From: Laura Gibbons
Sent: 23 June 2020 13:56
To: Planning.Responses <Planning.Responses@arun.gov.uk>
Cc: Simon Davis <Simon.Davis@arun.gov.uk>
Subject: N of Summer Lane P/35/20/DOC & P/37/20/DOC

We have the following comments regarding the revised surface water drainage details submitted for P/35/20/DOC and P/37/DOC.

Typical Gabion Rock Mattress Detail
Not to Scale

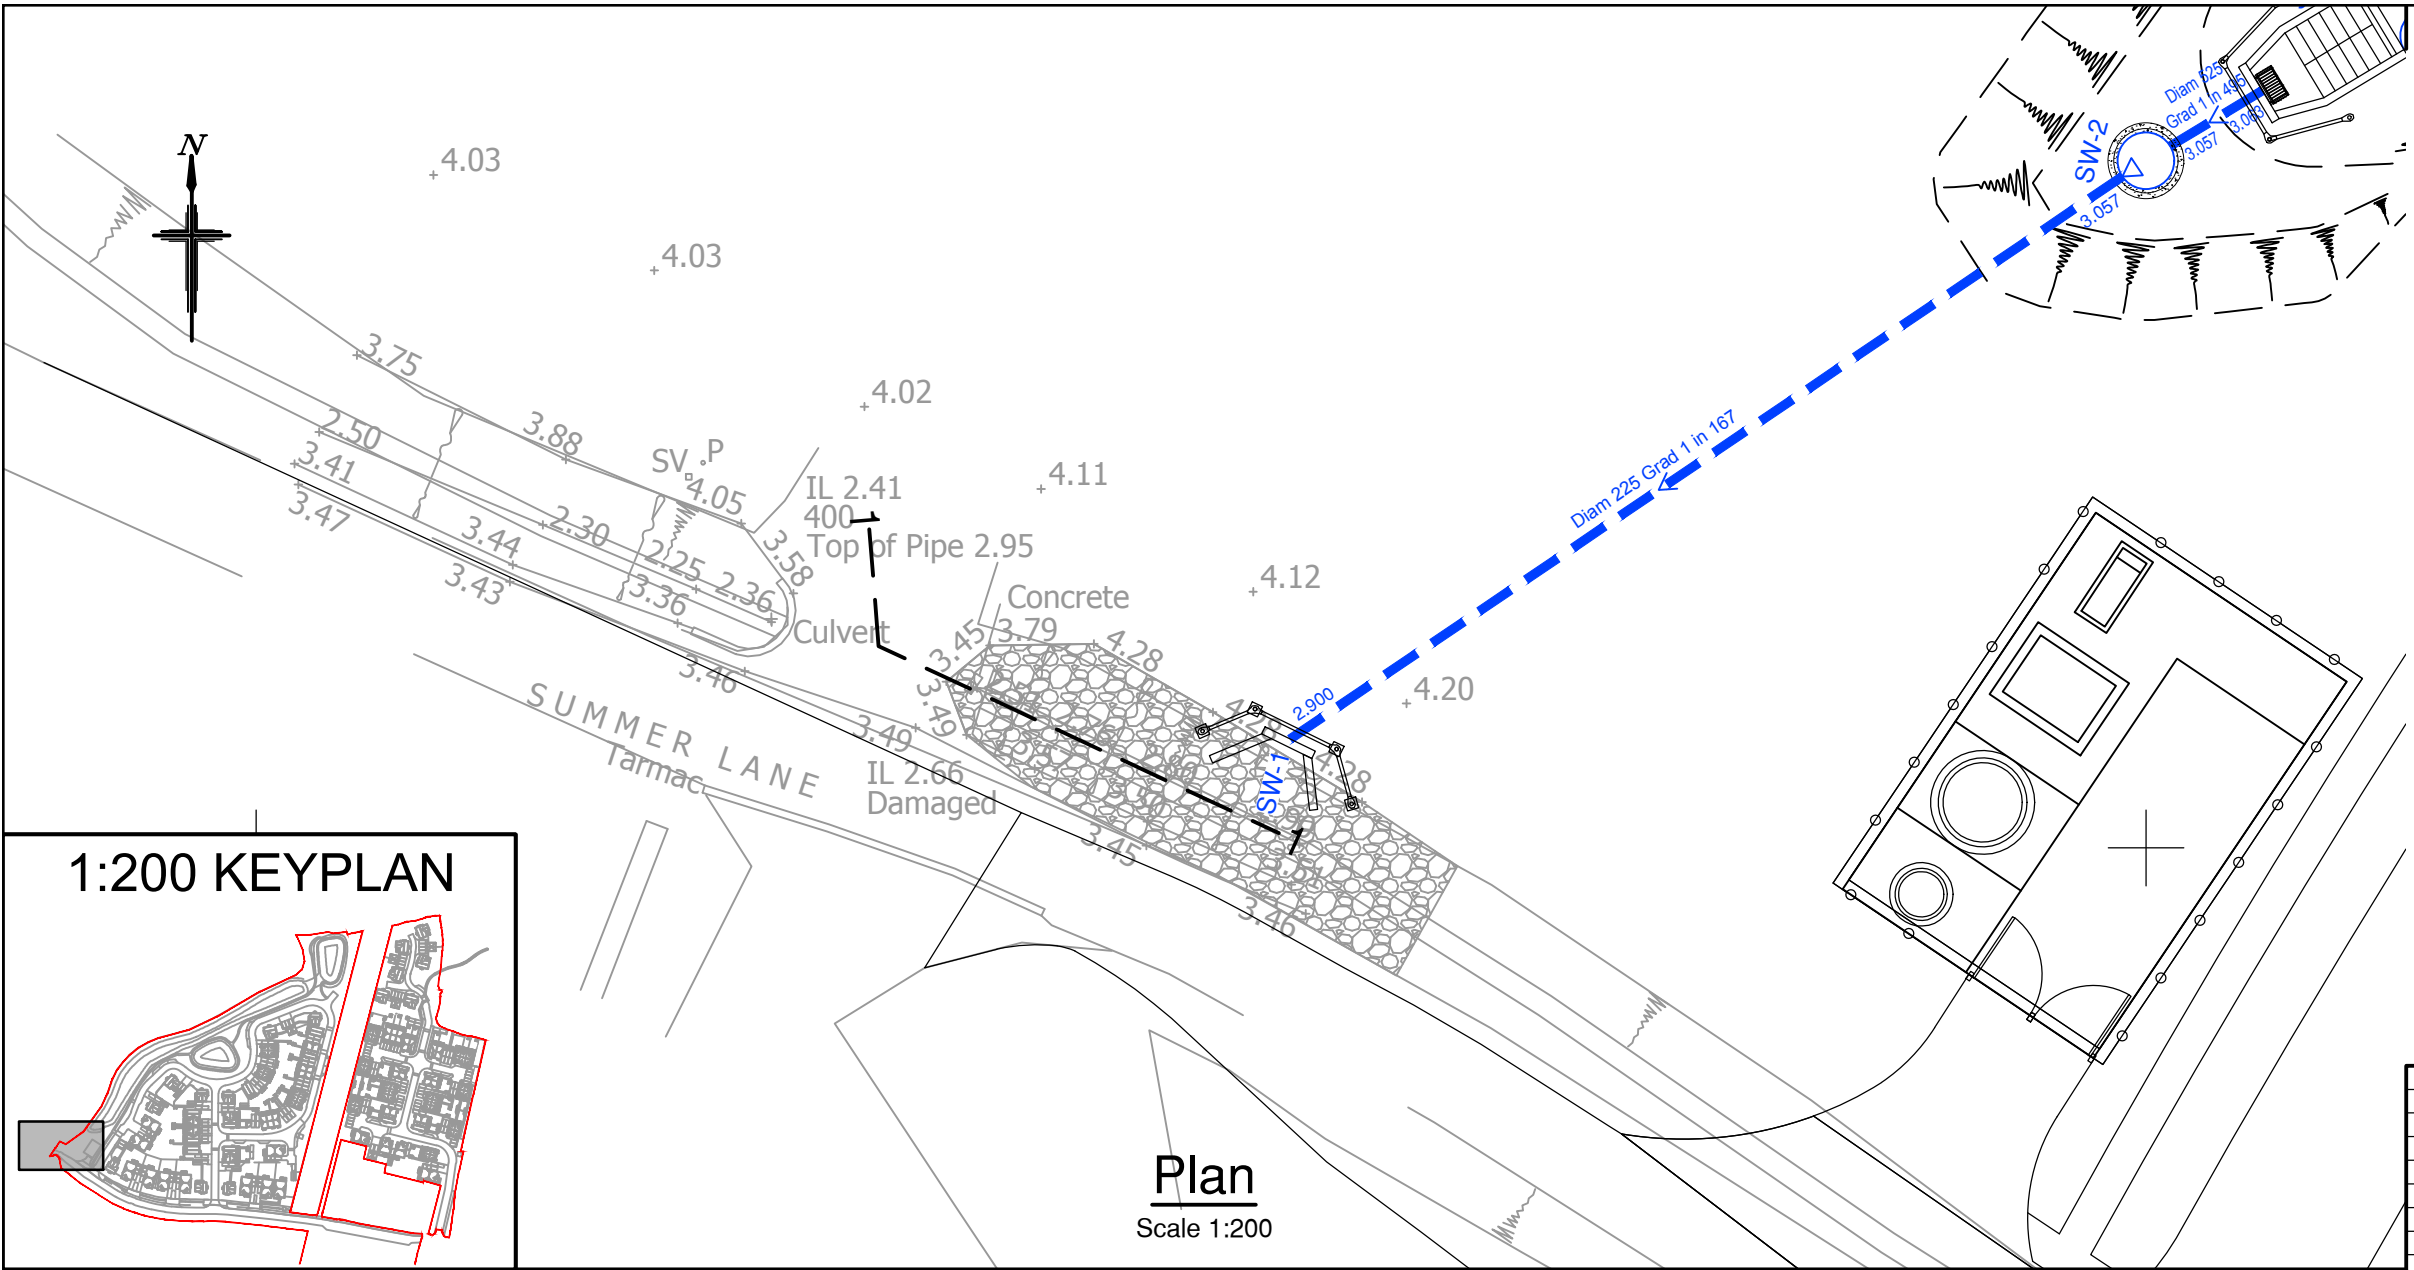
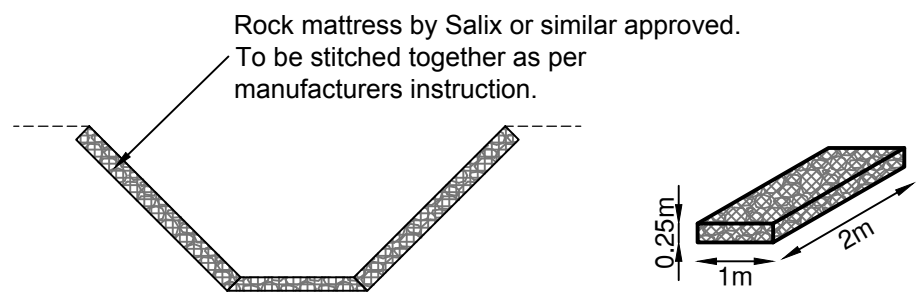
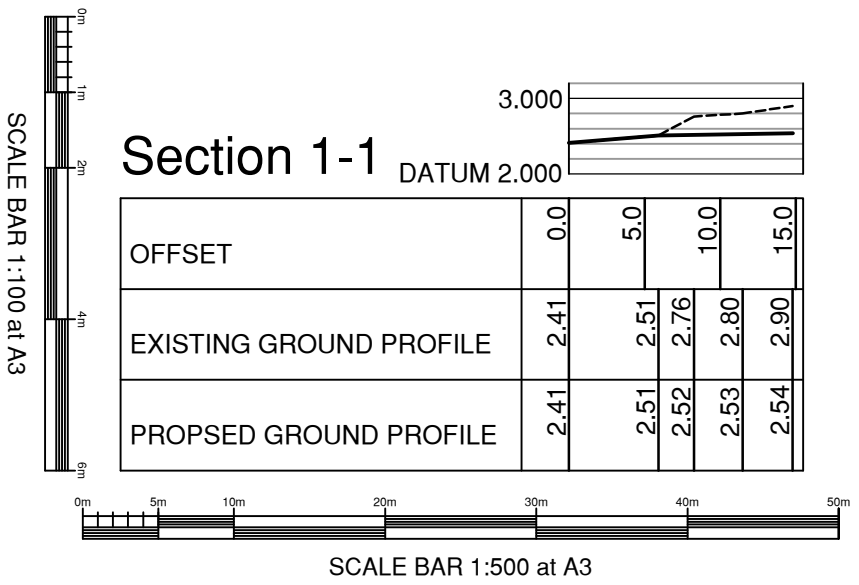
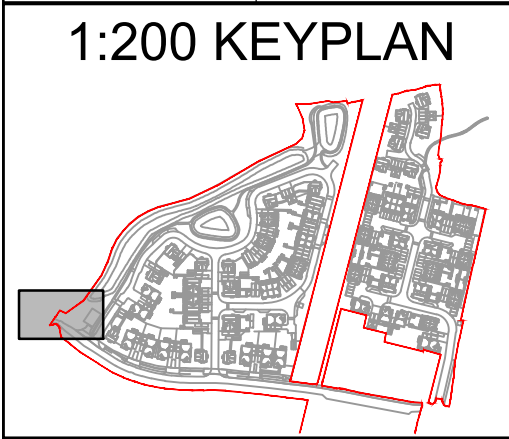
3. Provide full details of the proposed remediation works to the northern ditch and Crayfern outfalls. – *reference to be made to the OWC application and associated OWC response 22/05/2020 Cutting of headwall aprons and treating exposed reinforcement unlikely to provide a good long term solution, who is then going to be responsible for maintenance, if this is Crayfern then all proposals will require their approval too. Reconstruction may be better. Please provide details of anticipated*

design life of net gabions. Provide details of how future maintenance of ditches with this reinforcement will be undertaken- risk of damage. Have these proposals been run by an ecologist?

15. If gabions are to be utilised as part of the solution, bearing in mind item 6 above, then specify wire thickness/protective coating. *Salix gabion matatress detail added. Wire gabion mattresses preferred.*
